PLANNING AMENDMENT

Application no: H16/0611/97

Description: Extension of service yard area
and car park.

Location: Service Yard, Winsover Centre
Winsover Road
Spalding
Lincs

DRW NO:
7741A3106A

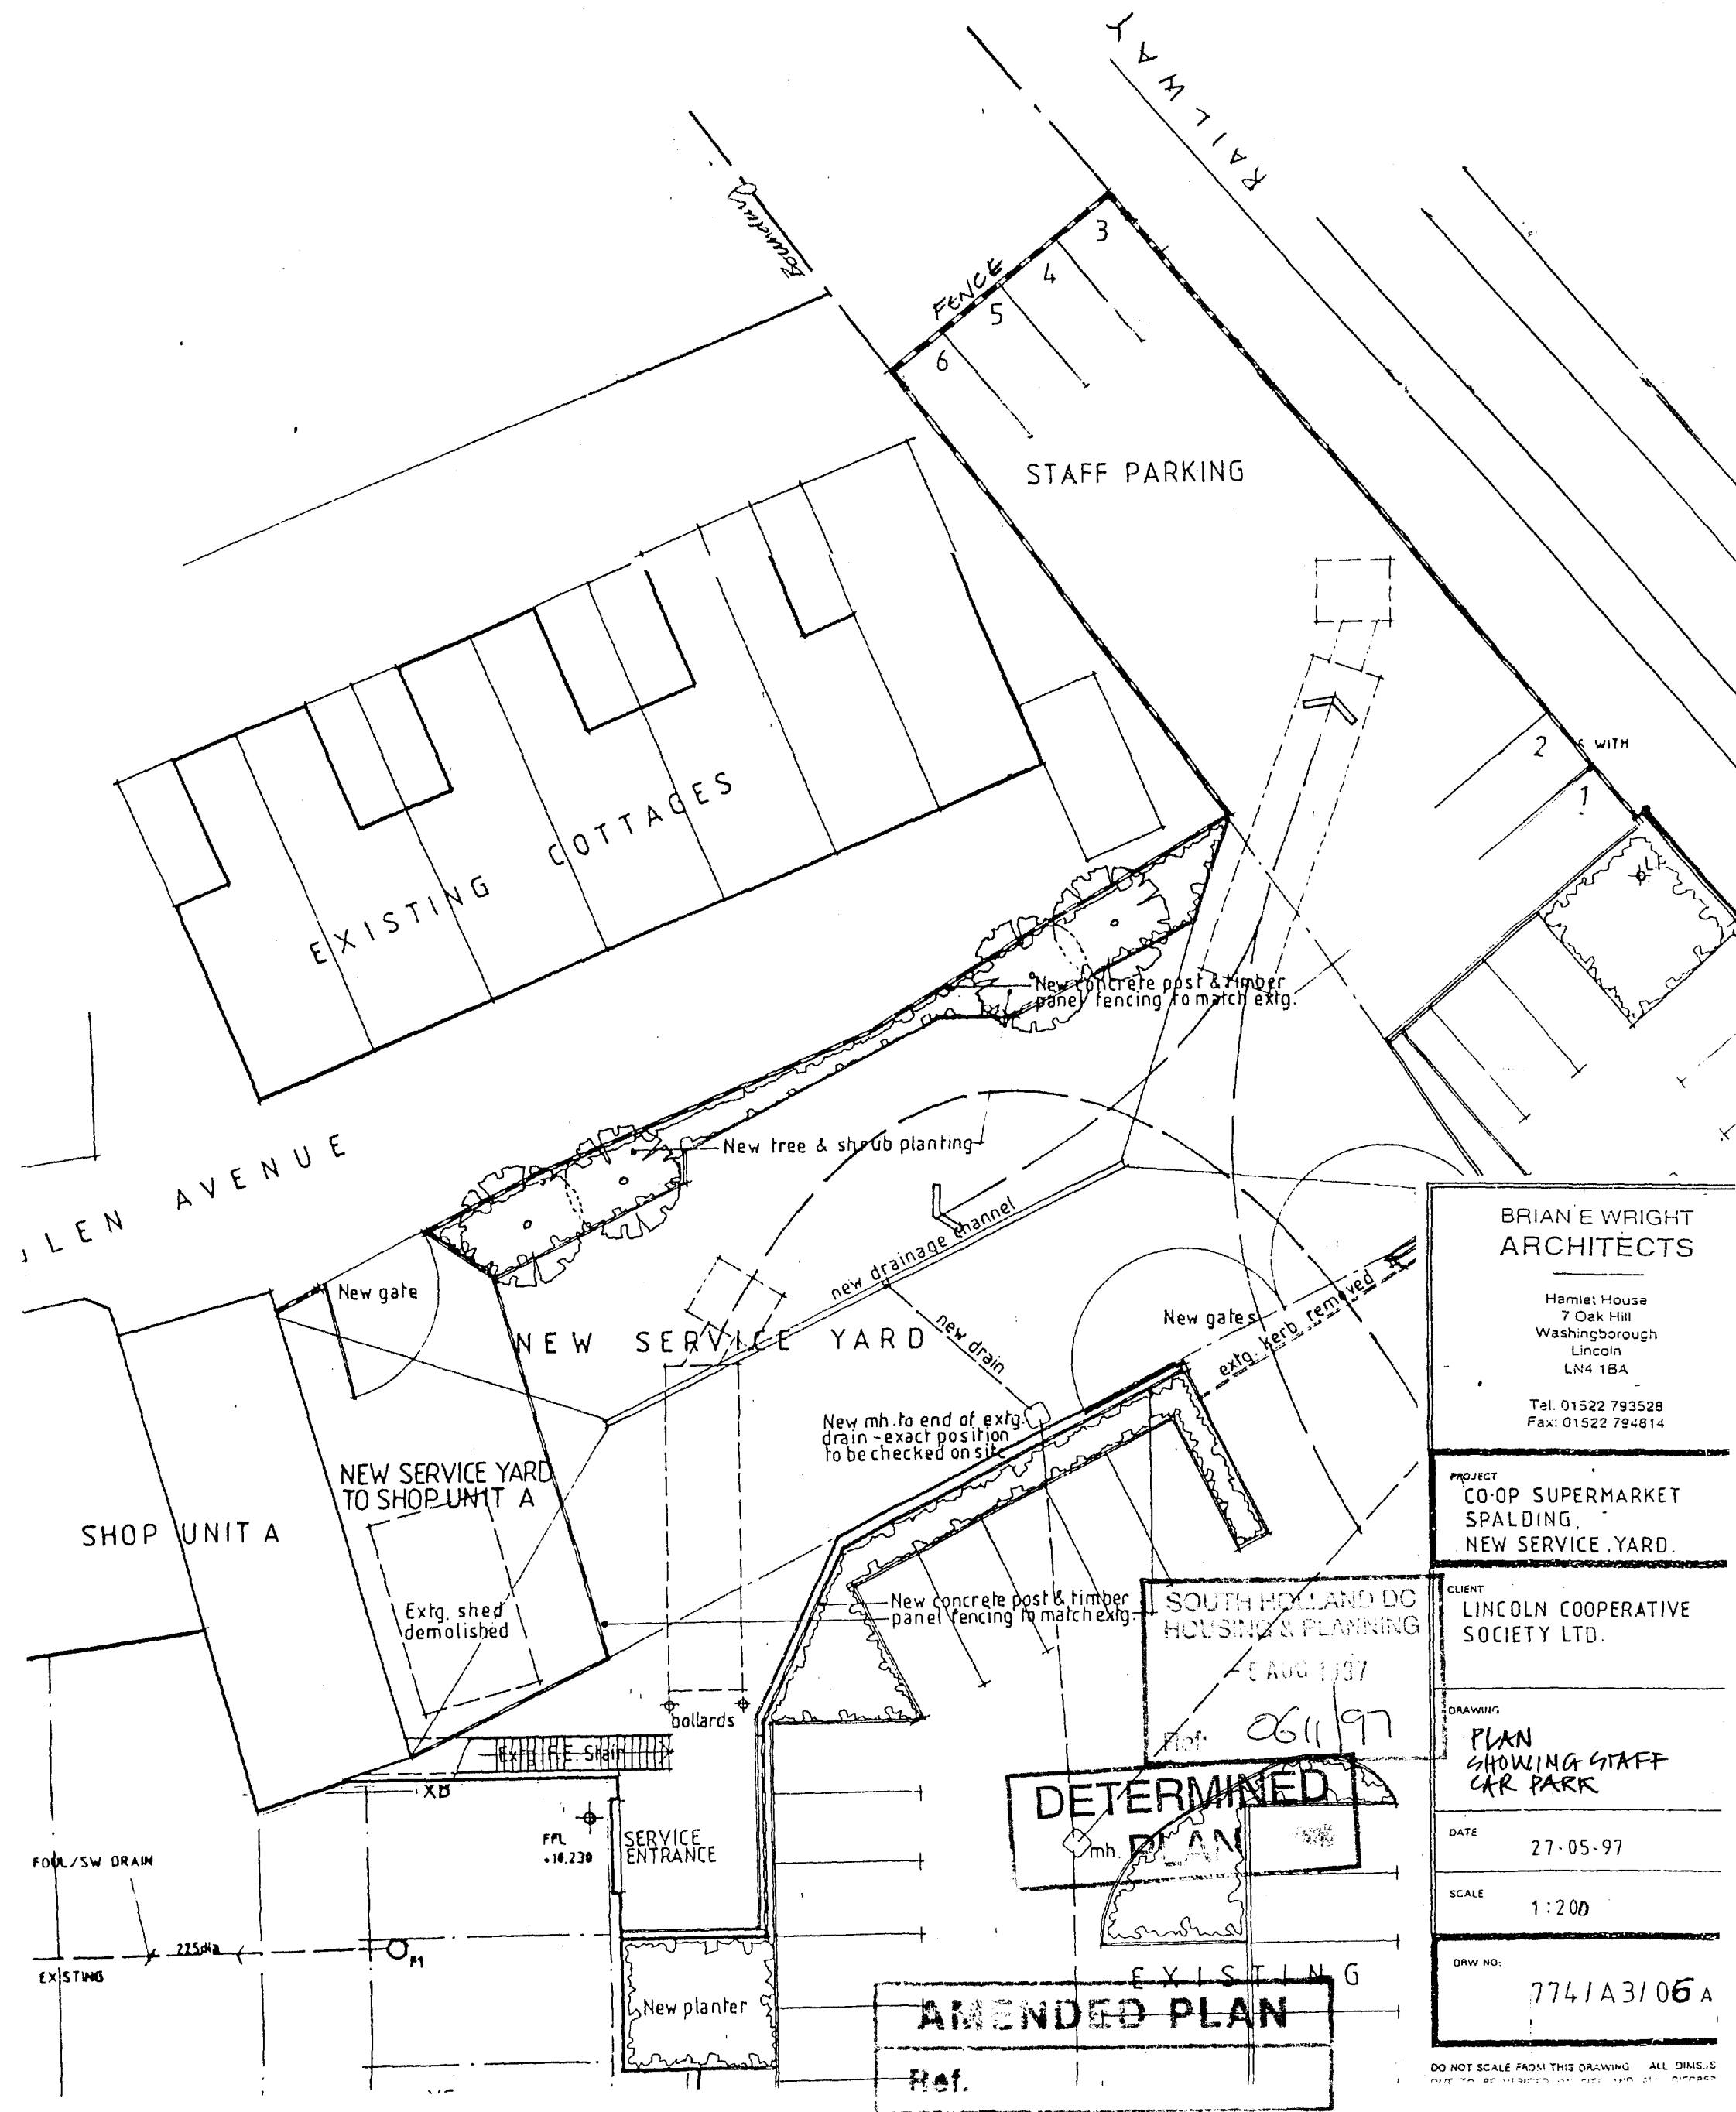
Exclude part
of Service yard

Amendment: Exclude part of service yard
Drawing No. 774/A1/02A and 774/A3/06A
